Submission - response to Inland Rail EIS, Illabo to Stockinbingal section.

**ILLABO TO STOCKINBINGAL Property Map: John Green "Omolue"**

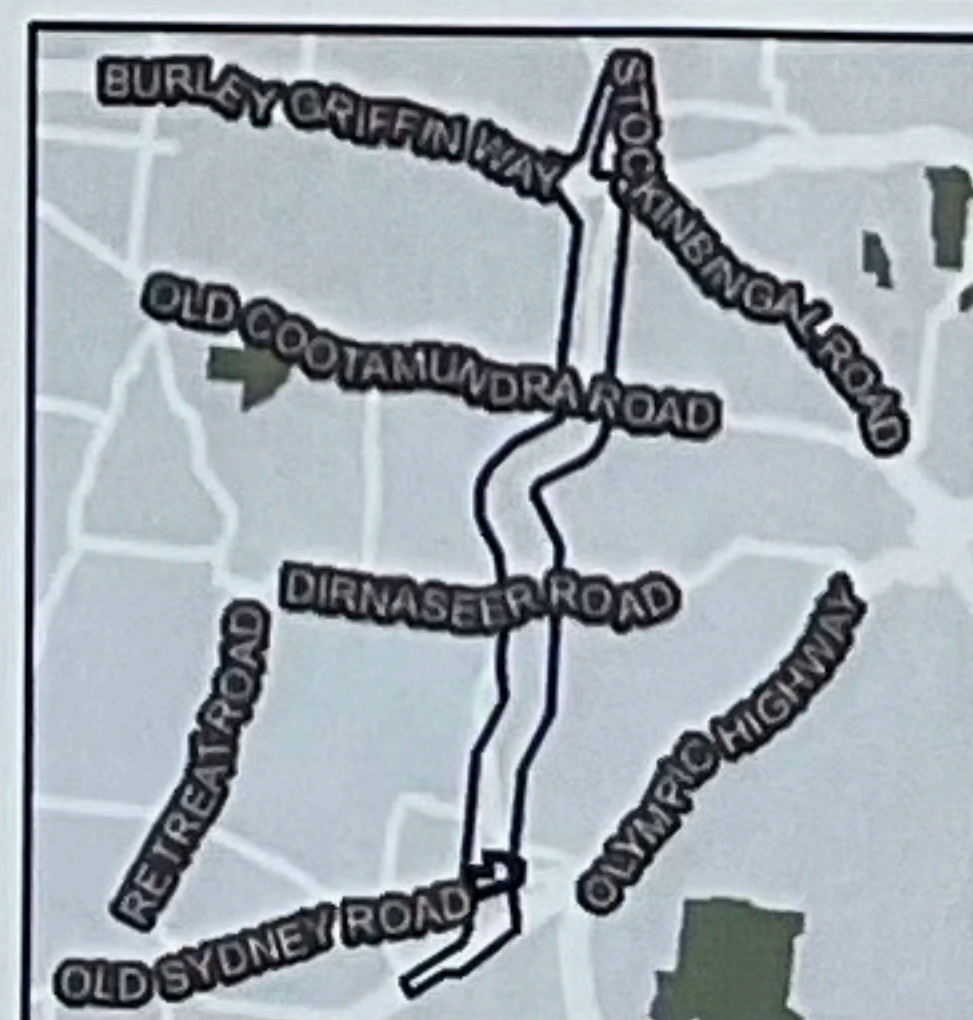
The construction of the railway line will completely dissect my property, line running north to south. The proposed connection between the two is a stock underpass, otherwise access is via the Old Sydney Road (**see Property Map attached and Front paddock to treeline copy photograph**) with new entrances on either side of the railway crossing. This will have create additional burden (time and manpower) of moving farm machinery/equipment to different parts or paddocks. Little consideration was given to providing an internal crossing over the railway line which could be used for moving such machinery and also sheep/cattle stock.

An underpass (3m x 3m) has been proposed (**see Property Map attached**) for the movement of stock and a vehicle to pass through. As it is difficult for sheep and cattle to move across railway lines created from light, noise and vibration, there is a need to construct holding yard on either side of the railway line and railings to direct stock.

- a. Creating a high pressure area through which sheep/cattle must move caused by train movements, noise and vibrations. This is intensified with the confined space to move stock through an underpass (tunnel) ie. 3m x 3m).

- b. There needs to be fencing and handling infrastructure in place to handle sheep/cattle to move through the underpass and to reduce stress on the animals particularly between train movements.

- c. The **width** of the underpass should be wide enough to allow several animals to be side by side so that there is a continual stock flow once the stock enter the underpass. It has been suggested by experts that a **width of 7 metres (one box)** more appropriate to allow a smoother flow or movement by stock. The **height** of the underpass **maintained at 3 metres** is sufficient. Backing gates would be installed to prevent stock coming back. **Winged walls** at the entrances would assist in directing stock towards the underpass.
